From: David [REDACTED]
Sent: 21 January 2022 08:52
To: Kathryn Welch <Kathryn.Welch@arun.gov.uk>
Cc: Architectural Fuller Associates [REDACTED]
Subject: Re: EP/163/21/HH 4 Selhurst Close

As discussed we are looking to recommend refusal of this application based on the garage and it being out of character with the immediate area.

Roof Plan
Proposed
1: 50

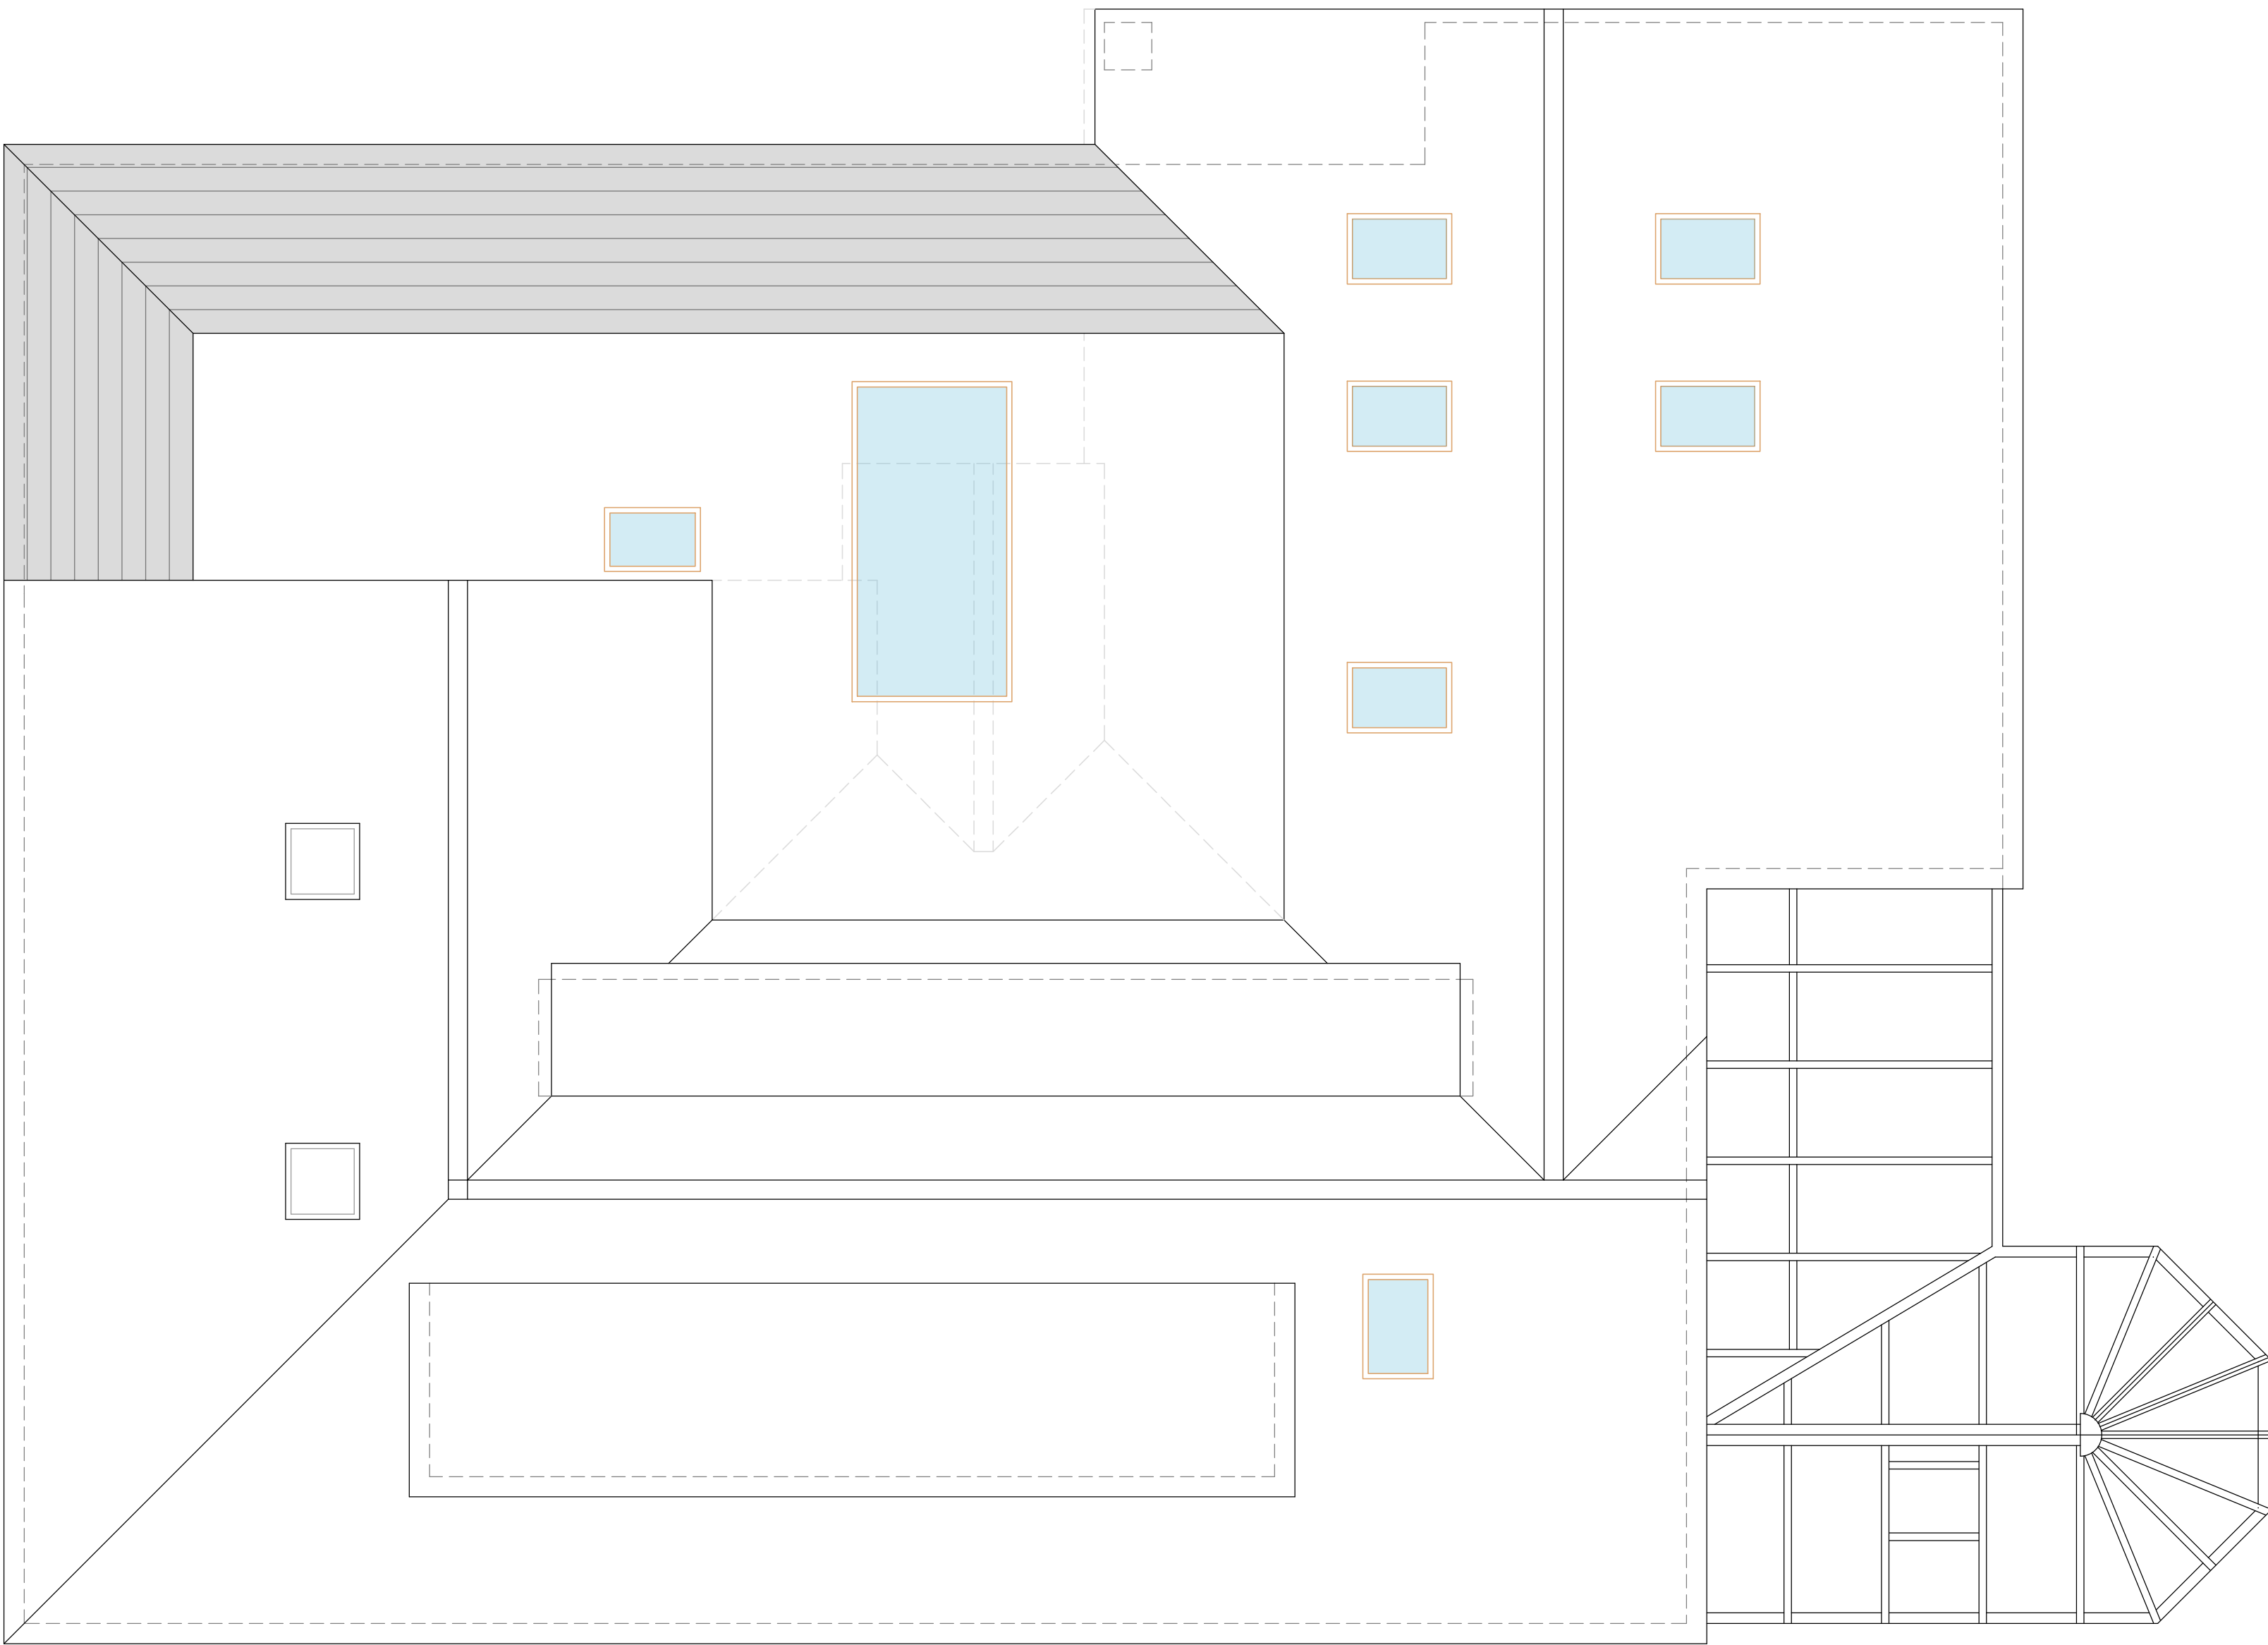
However, it is considered that the extension to the property is considered acceptable. Having viewed the plans I believe the extension to the dwelling to be subservient to the host dwelling, through its appropriate scale and materials choice, and I do not believe it will compromise the spatial character of the area, as the massing of the building is retained. Additionally, I do not believe the extension to be overbearing on neighbouring properties and no negative impact from overlooking is foreseen.
